North West Bicester

Title: Response to OCC Highways Comments

Date: March 2022

- 1.1 Jubb has been commissioned by Hallam Land Management Ltd (HLM) to provide highways and transportation advice in relation to proposals for a residential-led mixed use development on Land north-east of the railway line in North West Bicester.
- 1.2 This technical note sets out, in table format, a response to Oxfordshire County Council's initial transport and highways comments relating to the Transport Assessment that supports the planning application 21/04275/OUT submitted to Cherwell Council.

Bicester, NW
Development Framework Plan

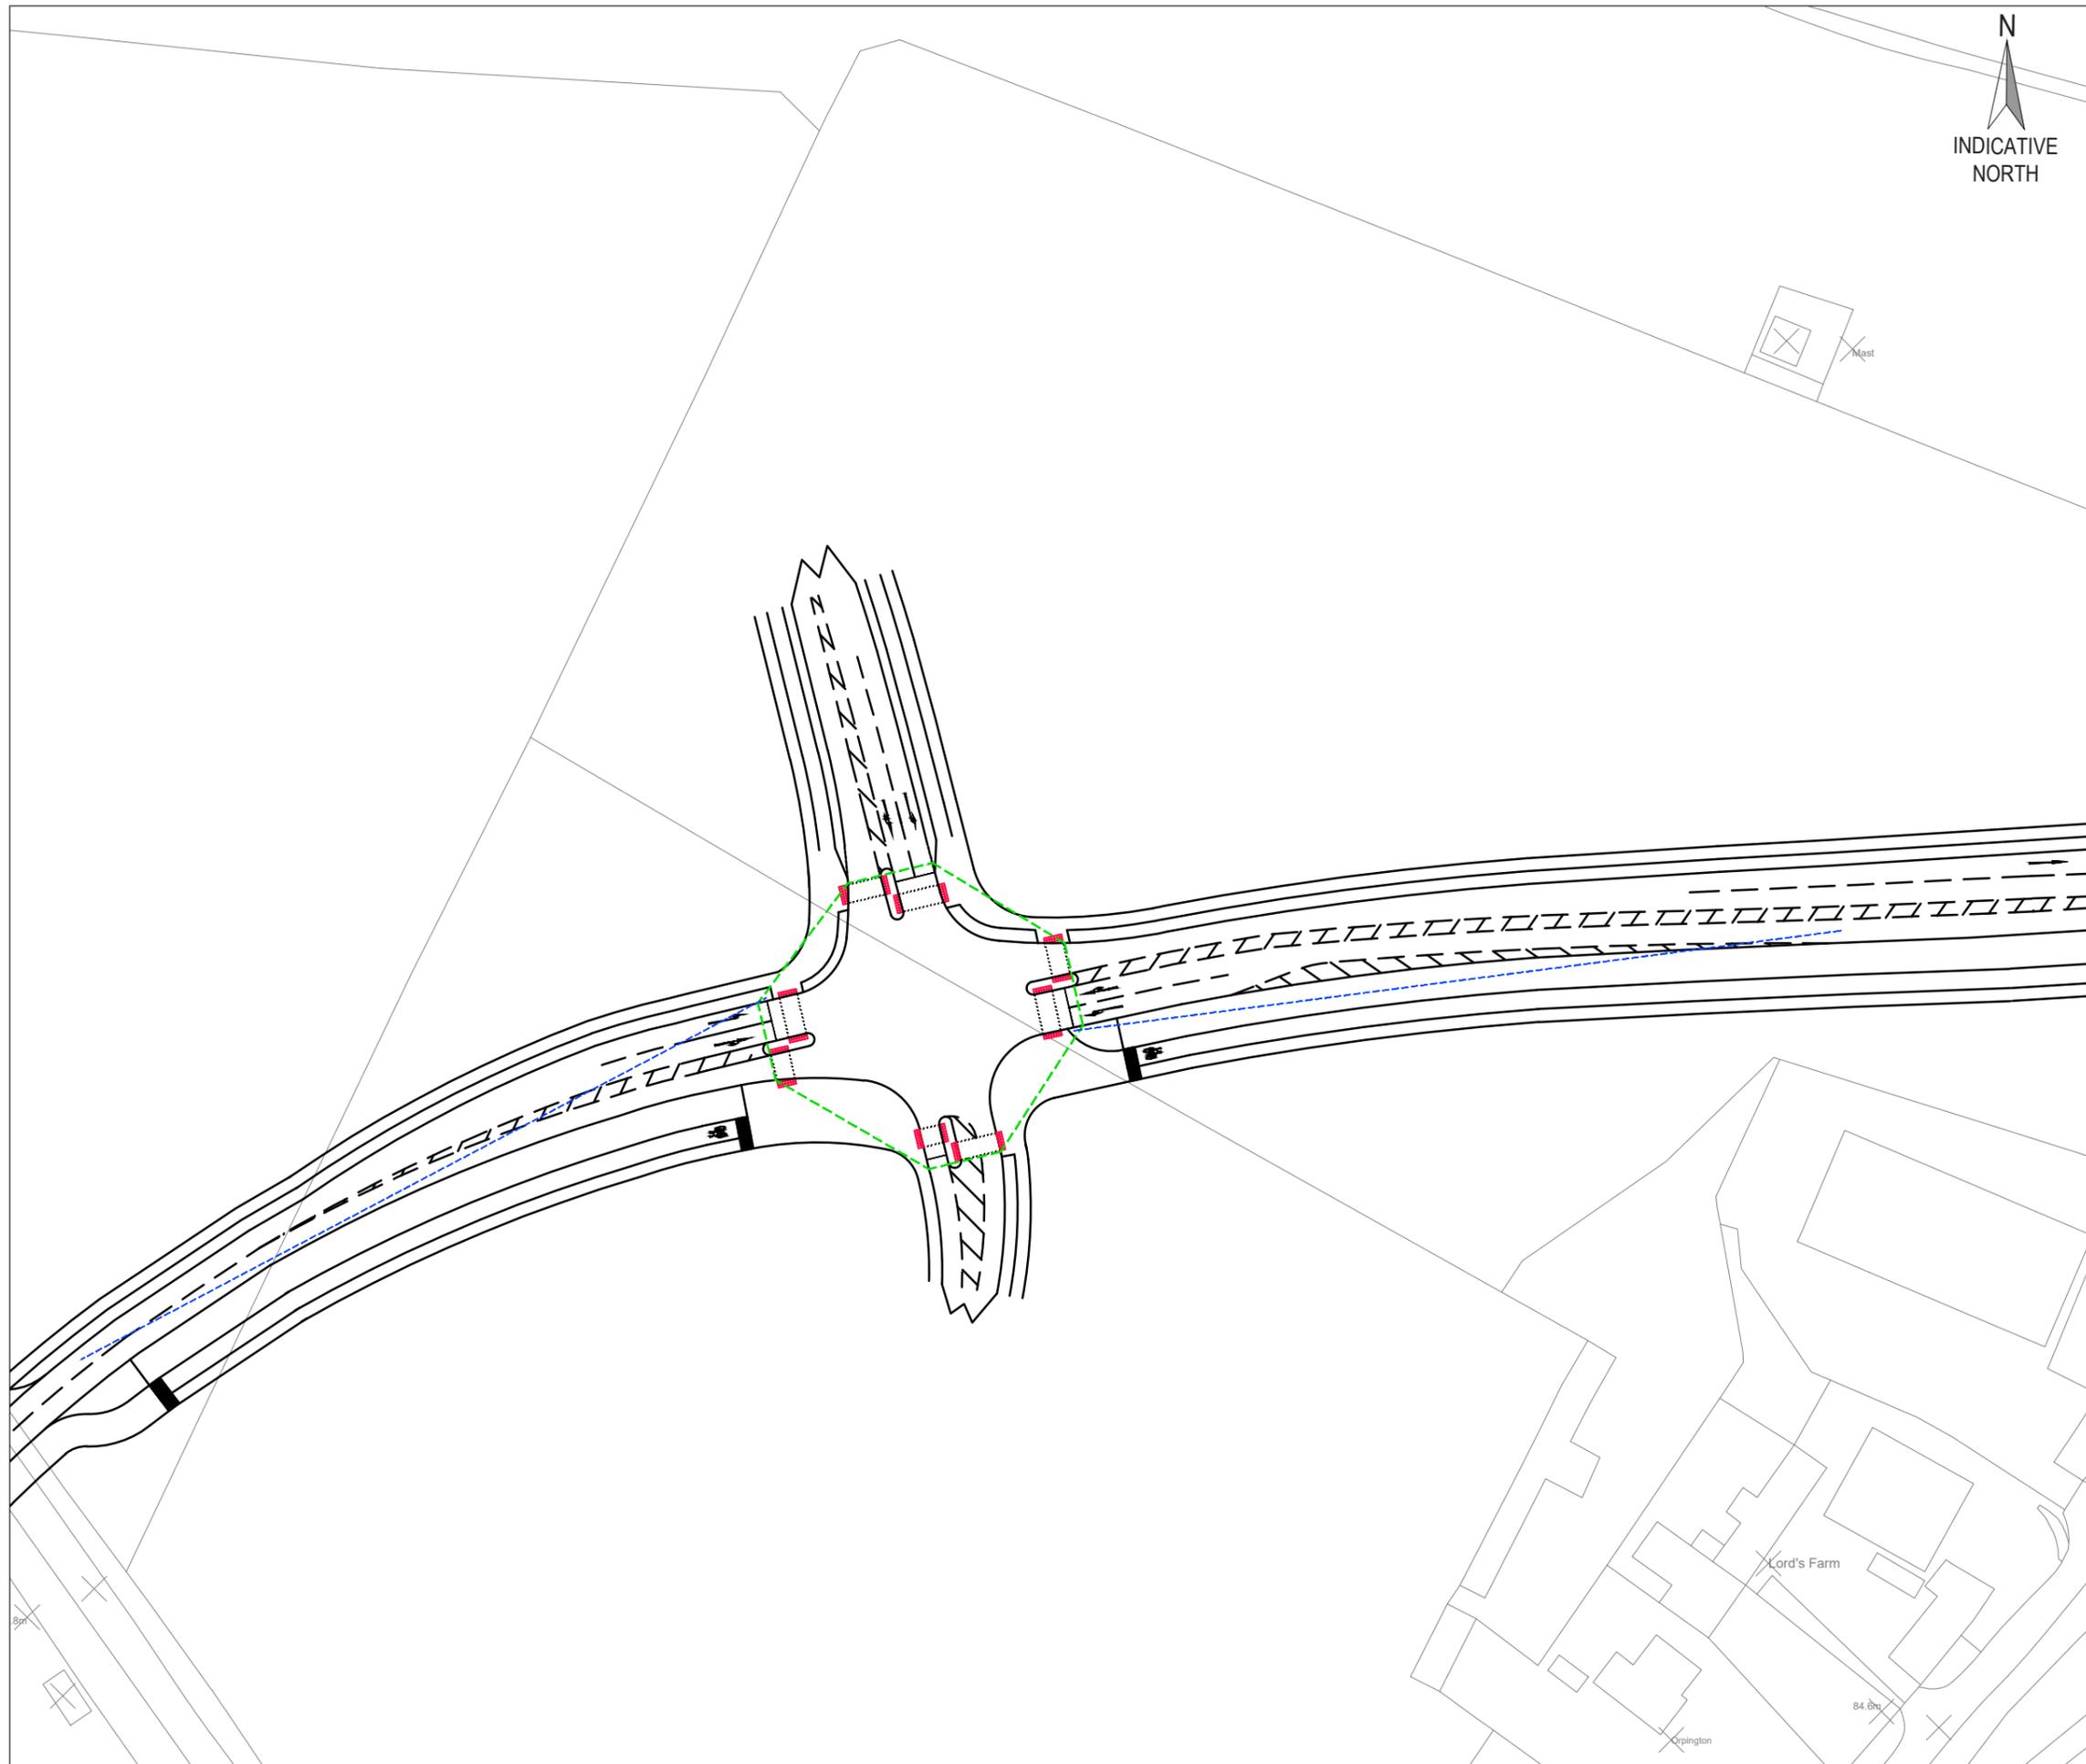
A number of accesses are indicated off Bucknell Road, and one off Bainton Road, for which no details are provided. As approval is sought for accesses as part of this outline application, details of each access from the highway must be provided as part of the application.	DLA are discussing this issue with CDC with a proposal to update the key on plan HLM066/026A to clearly shows accesses as illustrative and the proposal for the use of a condition to ensure details of the accesses are submitted and approve:
		"Notwithstanding the submission of drawing no. HLM066/026A in relation to the consideration for approval of the means of access to the Proposed Development, the Site Access positions for the 'Potential access from/to Elmsbrook', 'Indicative access to development parcels', 'access to allotments/open space (public) and cemetery' and 'Maintenance access to solar farm/Access to open space' are shown for illustration purposes only. Full details of the exact positioning and treatment of these site accesses shall be submitted to the Local Planning Authority for approval as part of the reserved matters application for that Part of the approved details."

Document / Paragraph	OCC Comments	Jubb Comments
	Walking and cycling routes: These routes should be included in the Development Framework Plan, together with connections to off site public rights of way. Key routes need to be secured through the planning permission to ensure that they are delivered in a timely fashion once the site is divided up onto parcels.	The proposed framework of walking and cycling routes together with connections to off-site public rights of wat are shown in Figure 7.5 which is a reproduction of the figure within the DAS (Part 6, page 89). A condition can be used to ensure key route delivery in accordance with the phased development.
	All the routes shown in Fig 4.3 should be LTN 1/20 compliant. Within the urban area there should be segregation between pedestrian and cycle routes and priority over minor roads. Details of connection points to the highway network must be shown as these are part of the access arrangements. A – important connection point to ped/cycle subway leading to the NW Bicester development S of the railway. To make best use of this it needs to be as directly accessible as possible from the whole of the site, so a connection along the red line marked in on the map below should also be provided. B – the NW Bicester Masterplan shows a connection onto Lords Lane/realigned A4095 here – this should be shown in detail as it part of the access arrangements.	Noted. Please see revised Primary Street cross section attached at Appendix A which shows 2m cycleways adjacent to the carriageway. It is considered that the 'purple route' within the development alongside Bucknell Road provides a suitable link via a proposed toucan crossing to the subway. The NW Bicester Walking and Cycling Strategy indicates a pedestrian/cycle route alongside the realigned A4095 and a leisure route within the development. However, it does not show a connection between.

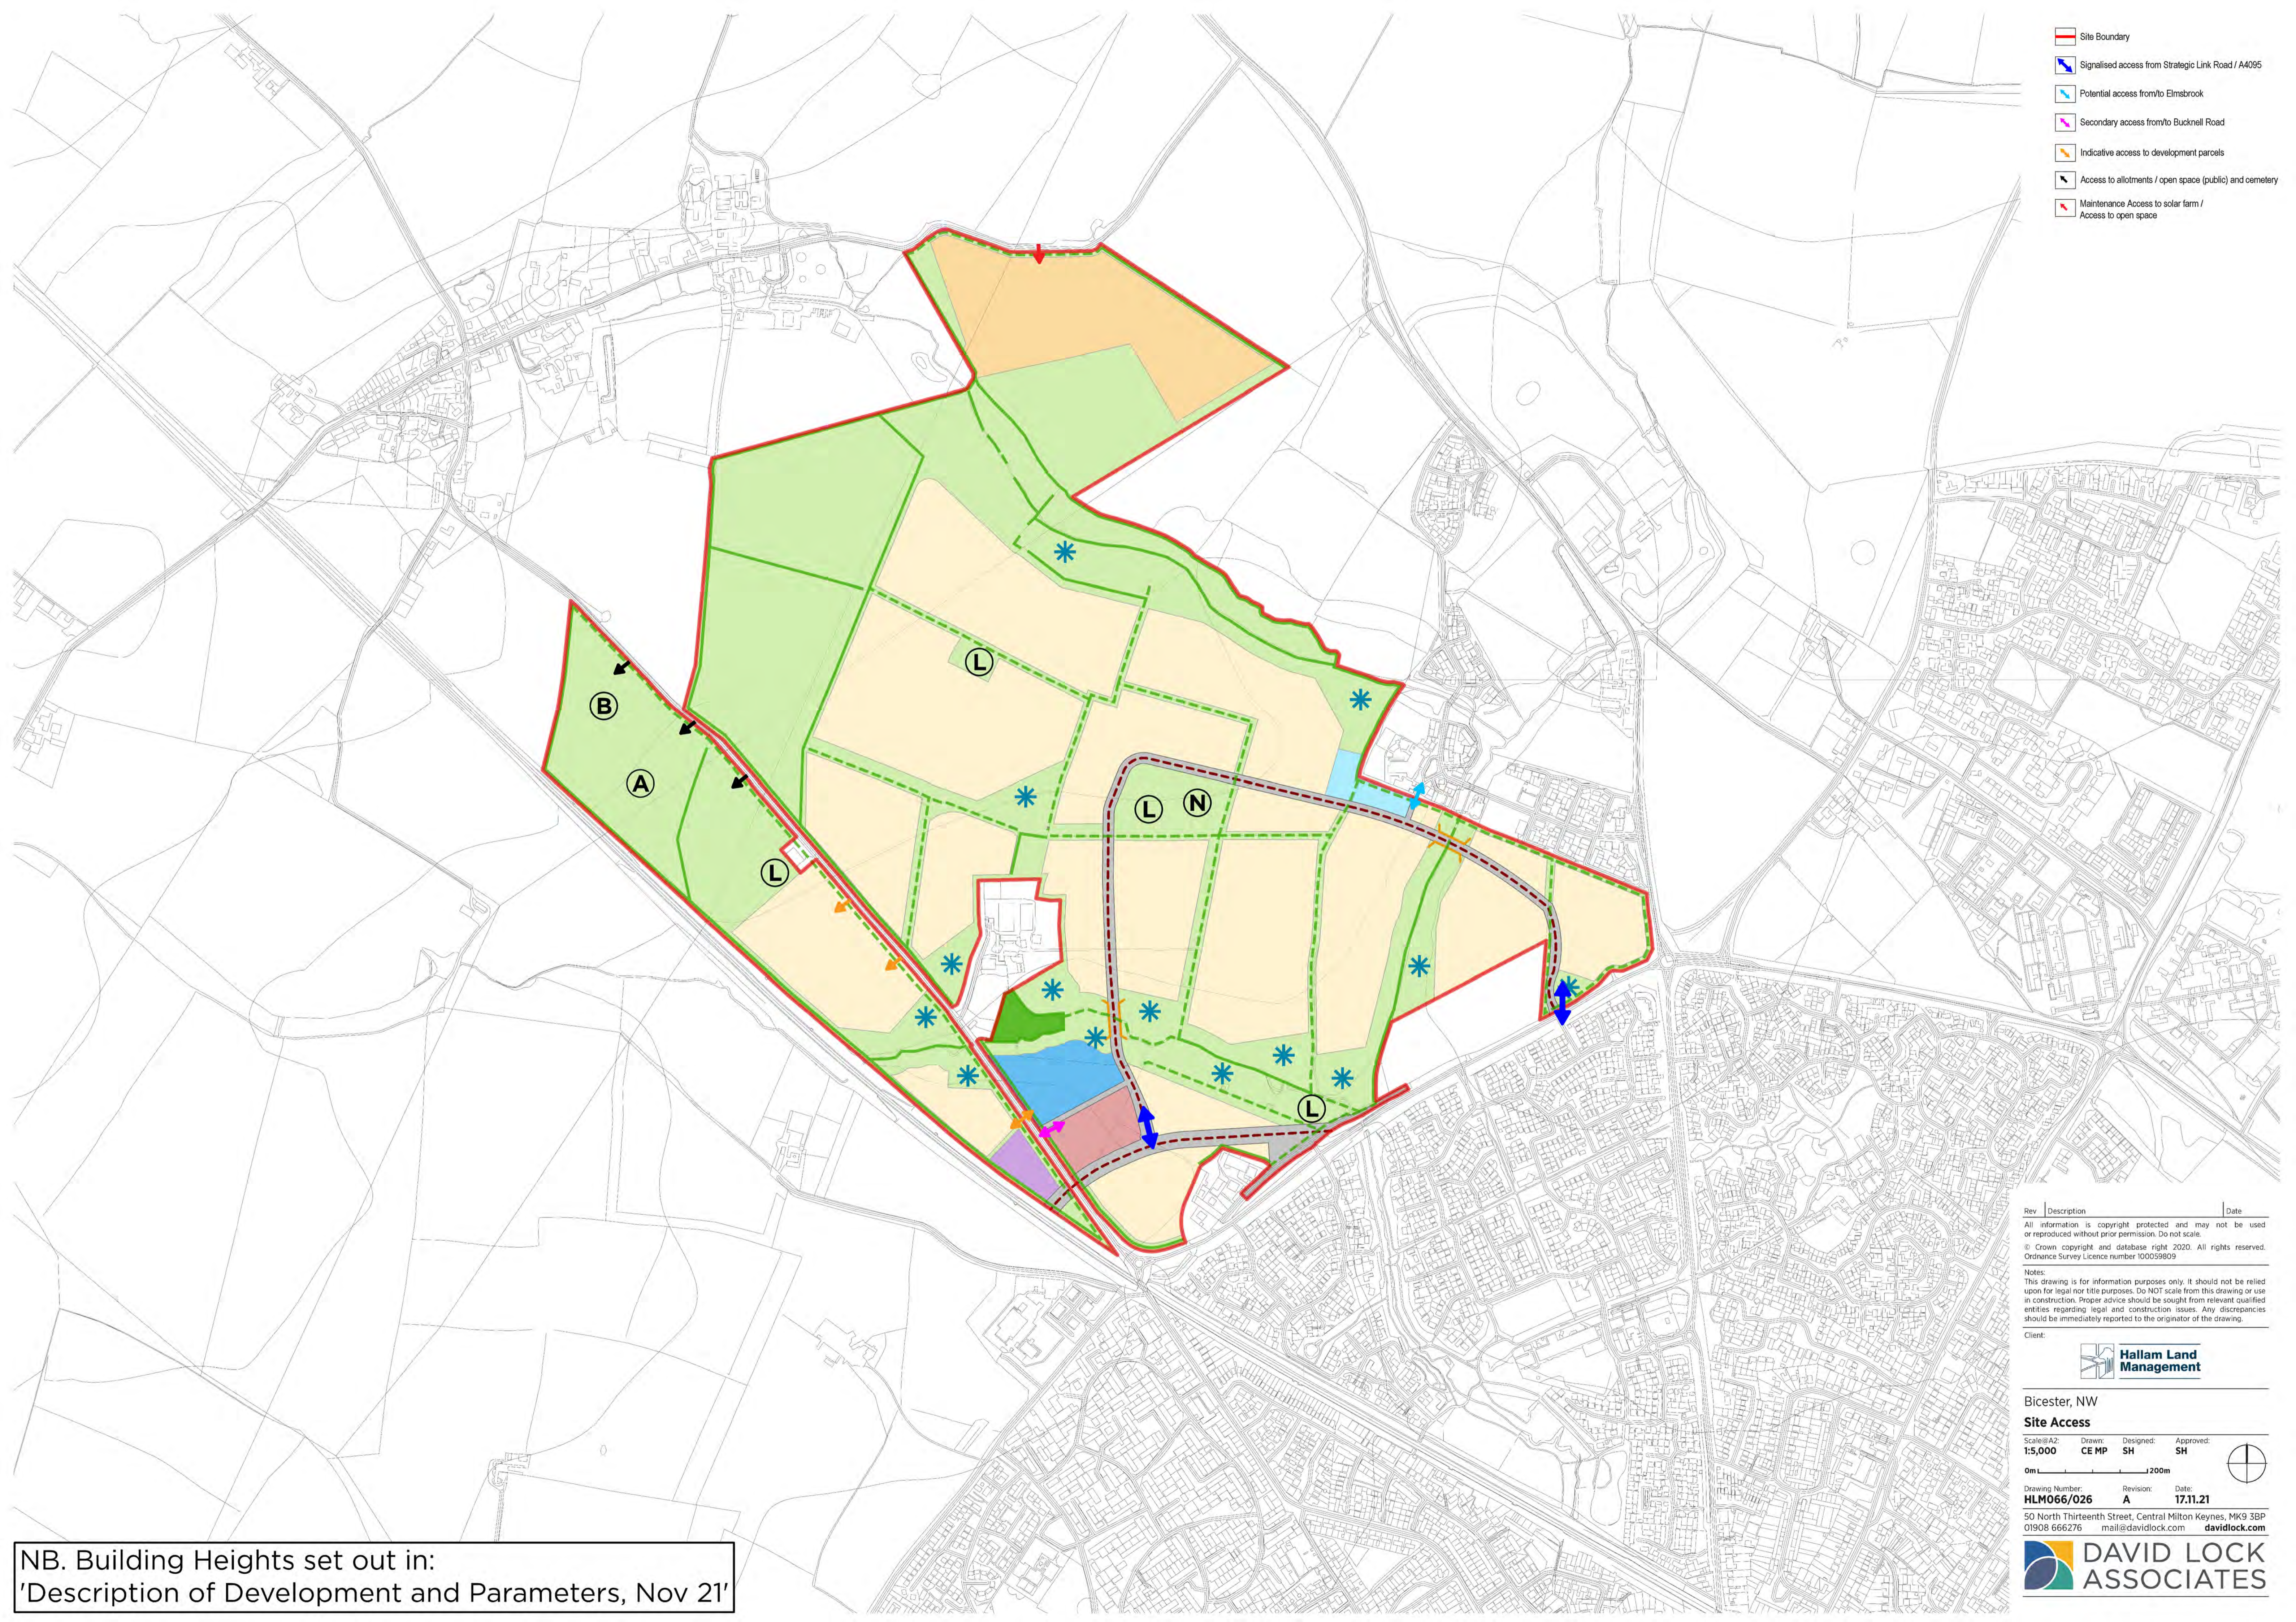
Document / Paragraph	OCC Comments	Jubb Comments
7.2.7	Access strategy: The access strategy includes primary accesses direct off the A4095 realignment. As this realignment is no longer programmed to be delivered by OCC the developer would need to provide both connections to Lords Lane, the southern connection being to a design to be agreed with OCC, to be compatible with future realignment of Lords Lane.	Noted. The proposed eastern access is formed from the existing alignment of the A4095.
	The realignment is necessary to distribute traffic from the development, avoiding the severely congested junction of Lords Lane/Bucknell Rd/Howes Lane. Whilst the developer could build the realigned road as far as the new railway bridge, there would need to be a limit on development coming forward before the onward connection south of the railway is opened.	Noted. See response to 4.3.3 above.
	Also two accesses are mentioned off the SLR (realigned section of the A4095). Only one is shown on the plan in Figure 7.4 – this needs clarification.	The western access will be taken from the SLR. The eastern access is taken from the existing A4095.

The bus only link between the A4095 realignment and Lords Lane/Bucknell Road is not shown - that was part of the NWB masterplan movement and access framework. However, provided an acceptable bus loop can be provided, to link with the bus route within the Exemplar site, this would be acceptable, as the buses could access the site from the Banbury Road rather than Bucknell	This bus only link was removed from the OCC design for the A4095 realignment, and the design reflects that.

Document / Paragraph	OCC Comments	Jubb Comments
	Road. However, the link through to the Exemplar site is only shown as a 'potential' access.	Noted. See response to 7.2.6/Fig 7.4.
7.2.8
